CITY OF PARRAMATTA

Our reference: SSD 7372
Contact: Brad Roeleven
Telephone: 9806 5600
Fax: 9806 5917

**STATE SIGNIFICANT DEVELOPMENT 7372
O'CONNELL STREET PUBLIC SCHOOL, PARRAMATTA
FENCING OF THE FORMER KINGS SCHOOL PARADE GROUNDS**

Figure130: Revised Fence Schedule, dated 6th May 2016.
Source: TZG 2016.

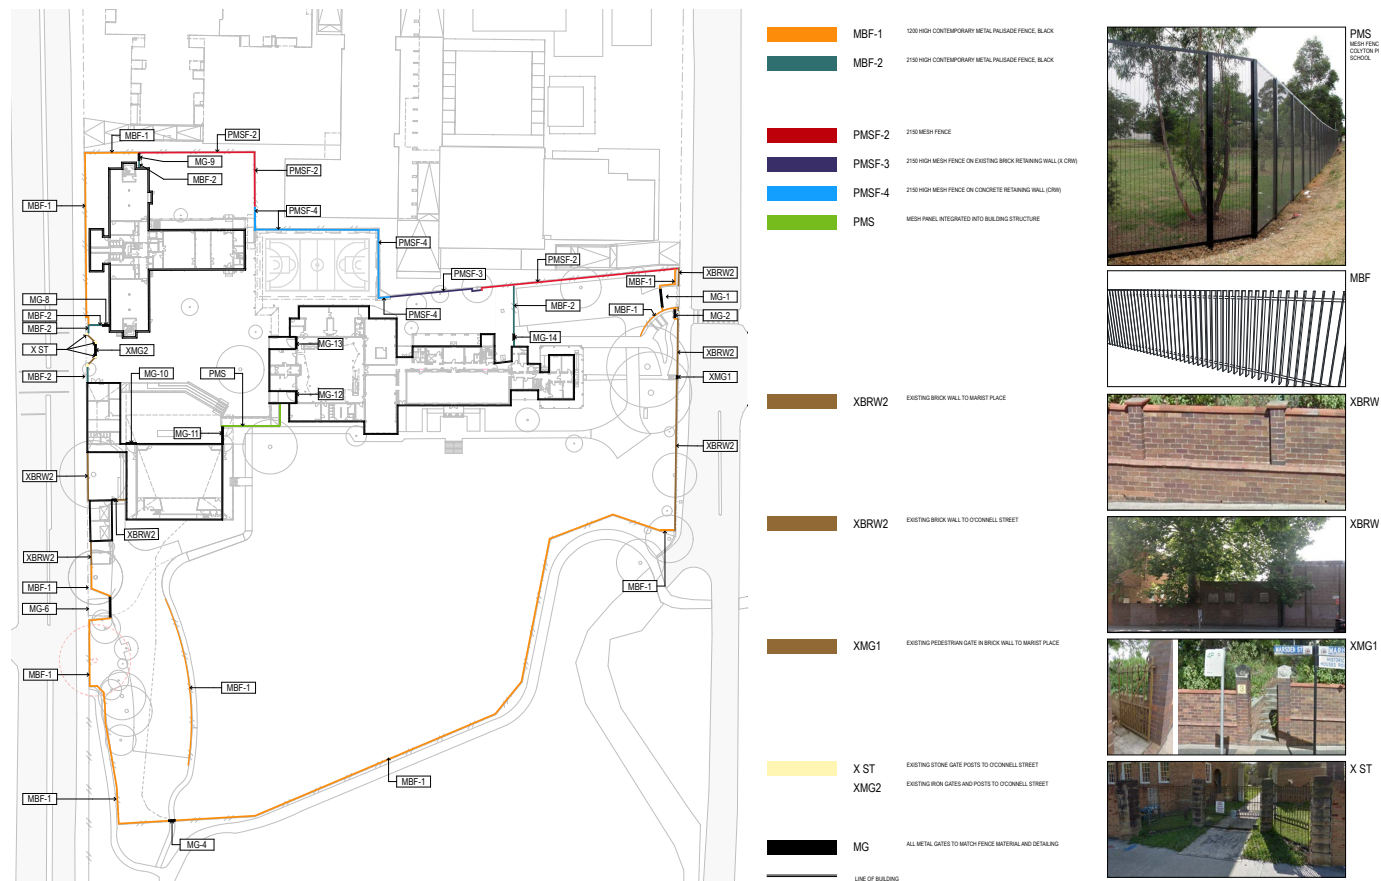
A fundamental concern with the SSD project is the DoE's intention to enclose the Parade Ground with a 2.1m high security fence. The location of the proposed fencing will have serious implications for the activation of the City and the River.

Council is therefore extremely disappointed with the preliminary details recently received from the DoE showing the SSD application will propose a continuous 2.1m high fence around the oval edge fronting the Parramatta River, O'Connell Street and Marist Place (refer to **Attachment A**).

- The alignments of security fencing should not prohibit the objectives and design strategies contained within the City River Strategy; and
- 2.1m high security fences are not appropriate along the boundary of the Parade Ground. Instead innovative and sympathetic fencing solutions are required for this location.

Council understands the preliminary view of the OEH is that the fencing as proposed would visually and physically alienate the oval from its river setting and therefore materially affect the significance of the former Kings School Group.

The Parade Ground is affected by both the 1 in 20 year and 1 in 100 year flood events, with a high hazard. In such an event, the proposed fence design and location could prevent appropriate egress for shared pathway users, potentially resulting in entrapment. Any fencing for this area must recognise that constraint, and be located and designed appropriately.
